**Re: MI Treehouse - CAO15-001/VAR18-002
CORE Project No. XX**

We have received the City's comments dated May 11, 2021 for the above referenced project. We have updated the plans and addressed each comment accordingly.

SITE PLAN
5637 MERCER WAY
MI TREEHOUSE, LLC
 11030 SE 30TH ST
 BELLEVUE, WA 98004

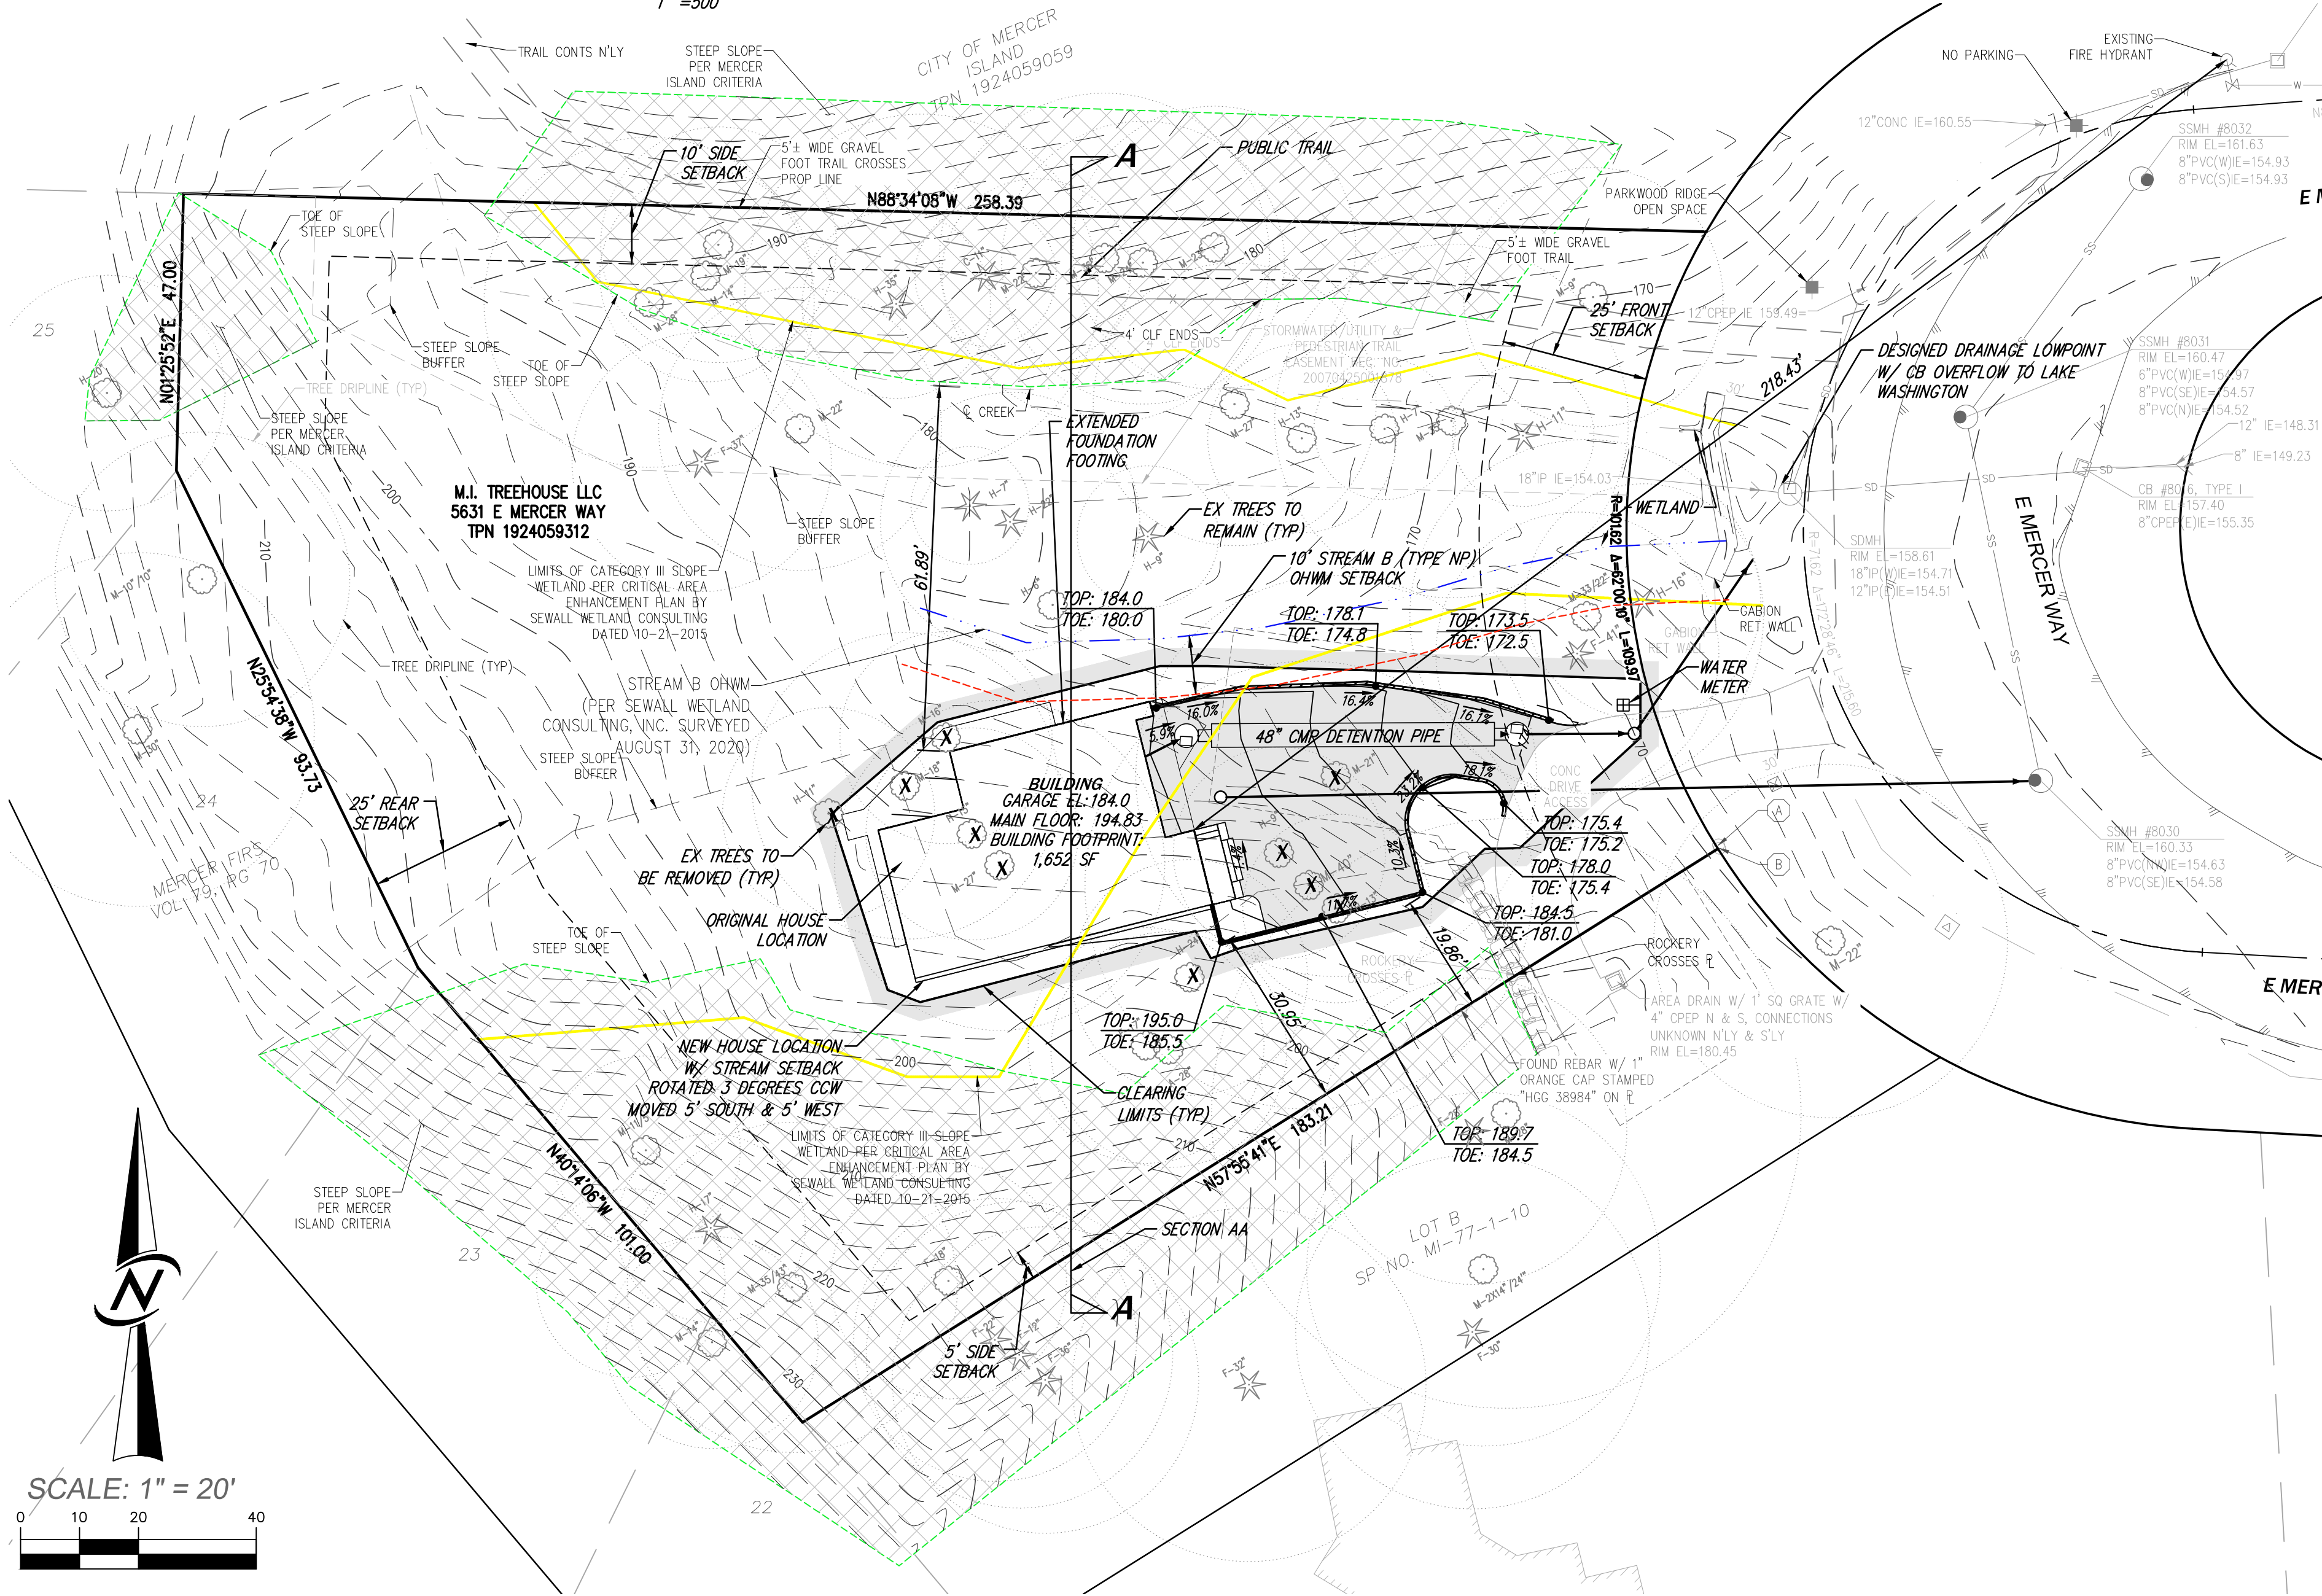
The revised site plan no longer depicts a retaining wall located west and southwest of the proposed residence. ESA previously commented on the wall and associated grading for the building foundation and potential impacts to wetland hydrology. ESA seeks clarification for the current lack of grading within the slope wetland to accommodate the structure. If grading is still required, ESA continues to recommend the applicant provide additional details about the onsite drainage system and how it will operate to not artificially drain wetland areas. Alternatively, the applicant can propose an offset from the drainage system that would account for lost wetland hydrology and mitigate impacts through additional credit purchase.

Response: The project team adjusted the grading approach to shift the house entry away from the south elevation and to the east elevation (consistent with garage entry). In addition, the team proposes shoring at the edge of excavation to minimize impacts to critical areas and their buffers. No retaining walls will be constructed west or south of the planned house, preventing disturbance of the steep slopes.

Also, the project team has adjusted the drainage system design to a larger diameter, but shorter, detention tank, and re-oriented it to better follow proposed driveway grading to allow for a shallower excavation with bottom of tank at or above the Stream B elevation. This will eliminate concern for draining the wetland areas during and after construction. Additionally, there is no long-term impact to wetland hydrology since the drainage system for the house slows down and redirects stormwater with discharge into the same system and immediately adjacent to the project parcel (negligible distance downstream for any long term impacts). In essence, the water that currently flows through the soil beneath the house site toward the wetland and stream will continue to be discharged to the wetland and stream.
